DECISION DELEGATED TO HEAD OF PLANNING

Application No: H06-0134-22 **Applicant:** Mr A Hay
Proposal: Residential Development - Erection of Dwelling
Location: Adj. Park View Dawsmere Road Gedney Drove End
Terminal Date: 5th April 2022

CASE OFFICER ASSESSMENT

Job Ref.		Drawing No.
3962-21		02A
Date	Drawn	
JANUARY 2022.	S.D.	
Scales		
AS SHOWN		
DO NOT SCALE FROM THIS DRAWING		
Project		
ADJ. PARK VIEW		
DAWSMERE ROAD		
GEDNEY DROVE END LINC'S PR22 9PL		
Client		
MR A. HAY

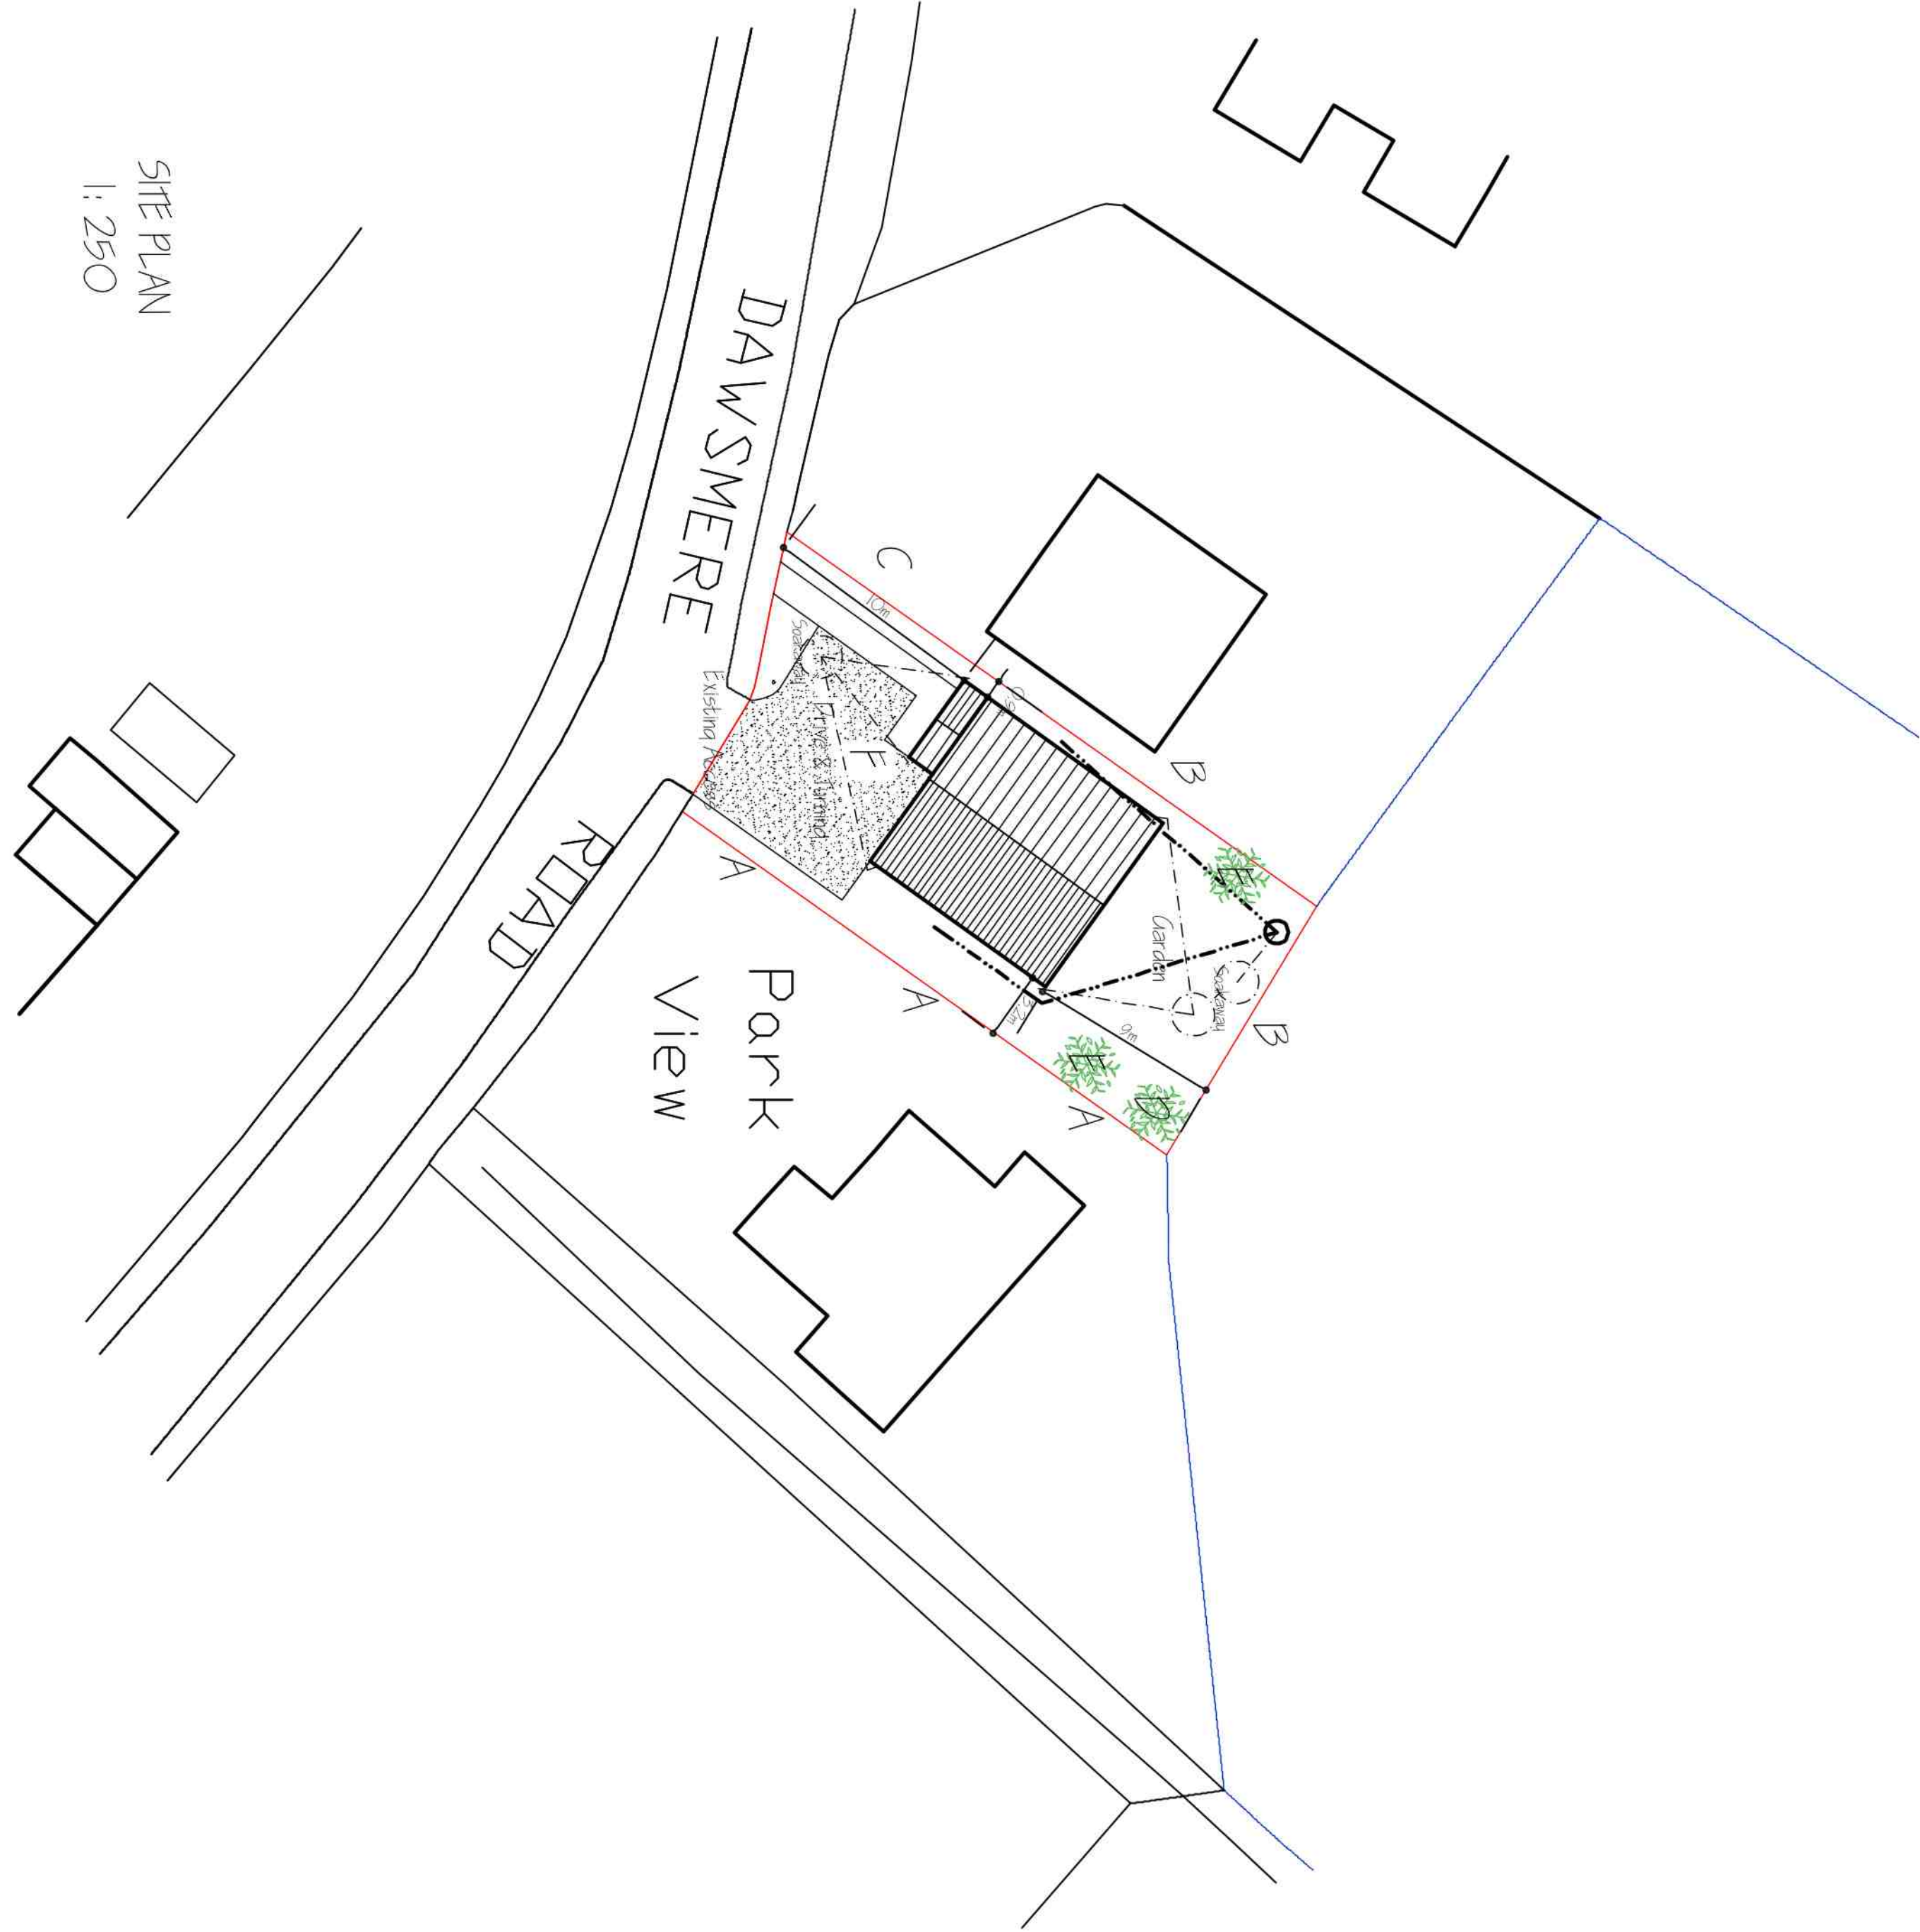
Additional tree planting is proposed at the rear. A condition should be imposed on any permission requiring bio-diversity measures.

The design of the property and general relationship to neighbouring development is such that the amenity of neighbouring residents would not be materially harmed in terms of overlooking, lack of privacy, overshadowing, overbearing effect, noise and disturbance, etc, subject to appropriate boundary screening.
